Application no: H06-0864-11

Description: Detached double garage (retrospective)

Location: Chailey House
Chapelgate
Gedney
Spalding
PE12 0BJ
PE12 0BJ

Amendment: Position and distance from Chapelgate
(dwg. no. 2104-10-03C)

Drawing
LOCATION & SITE LAYOUT PLANS.

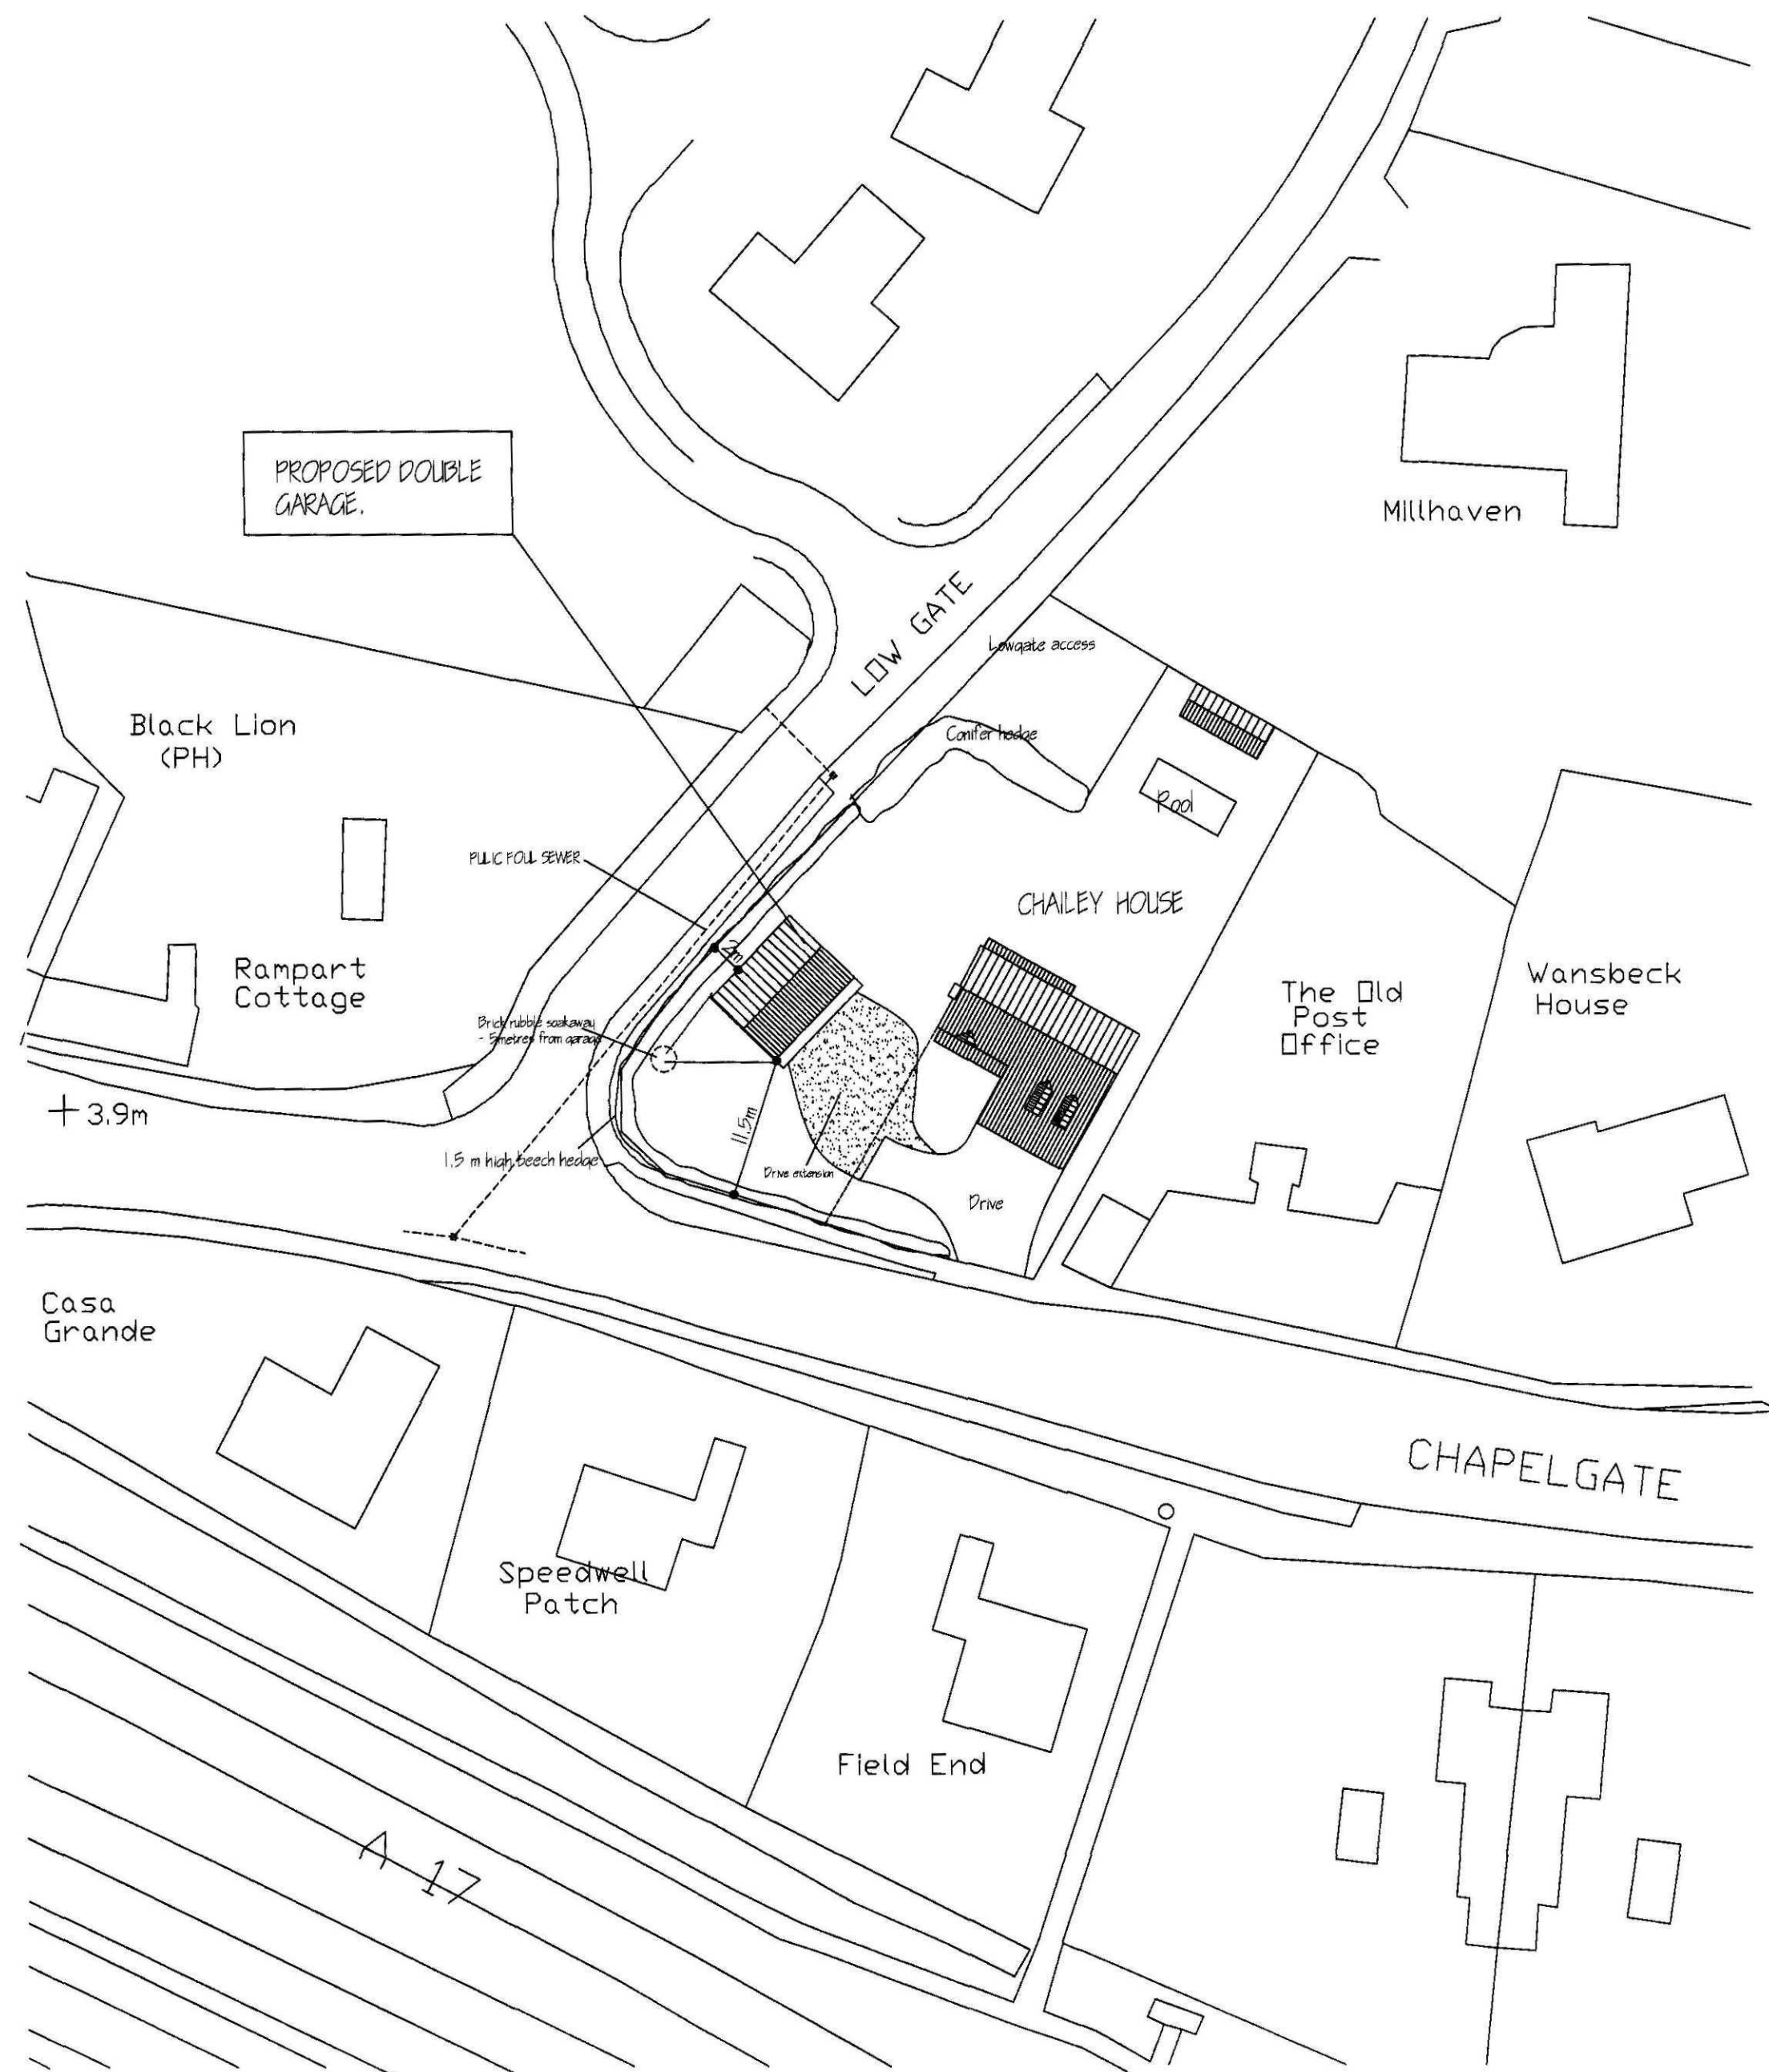
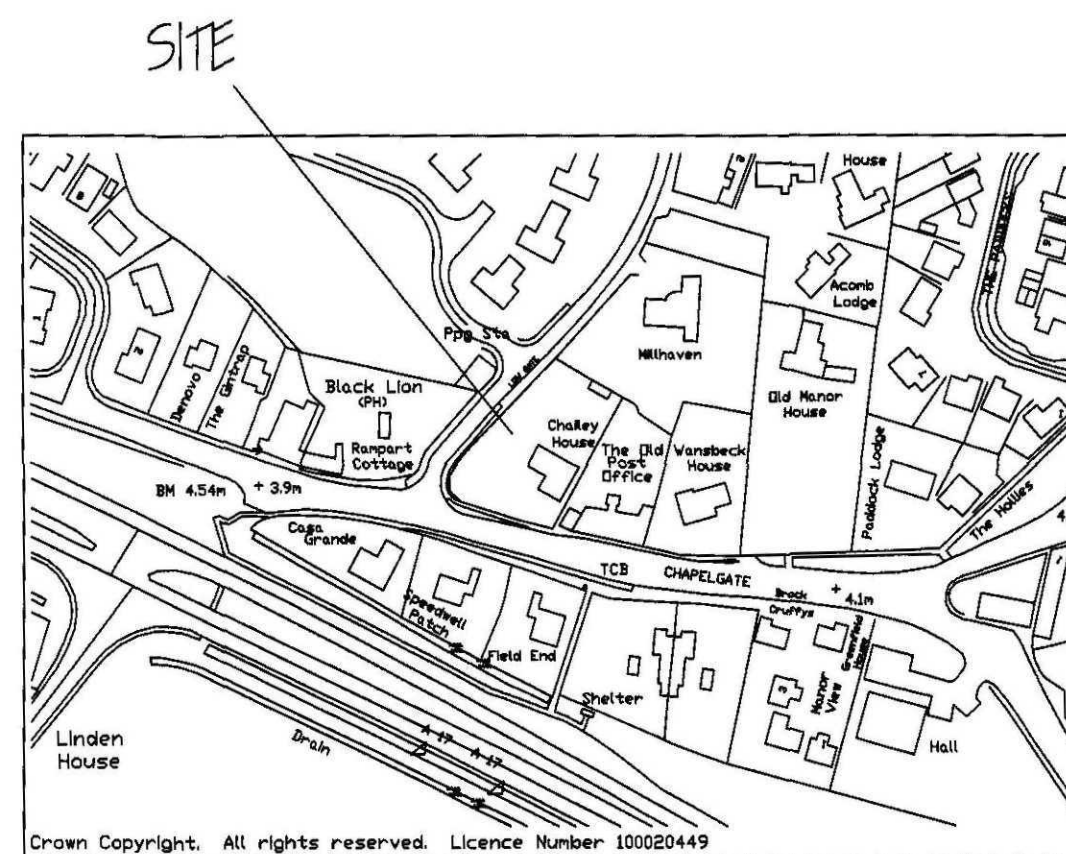
When the earlier application was considered you indicated (via email) that the garage is positioned 11.5 metres from Chapelgate (dwg no 2104-10-03C). However, the drawing accompanying this application only shows it to be 11 metres. Please submit an amended plan which revises the distance.

Following your email of 15th December please find attached a copy of drawing 2104-10-03C. this was originally approved under reference H06-0389-11. we apologise as the wrong drawing was sent in with the current application.
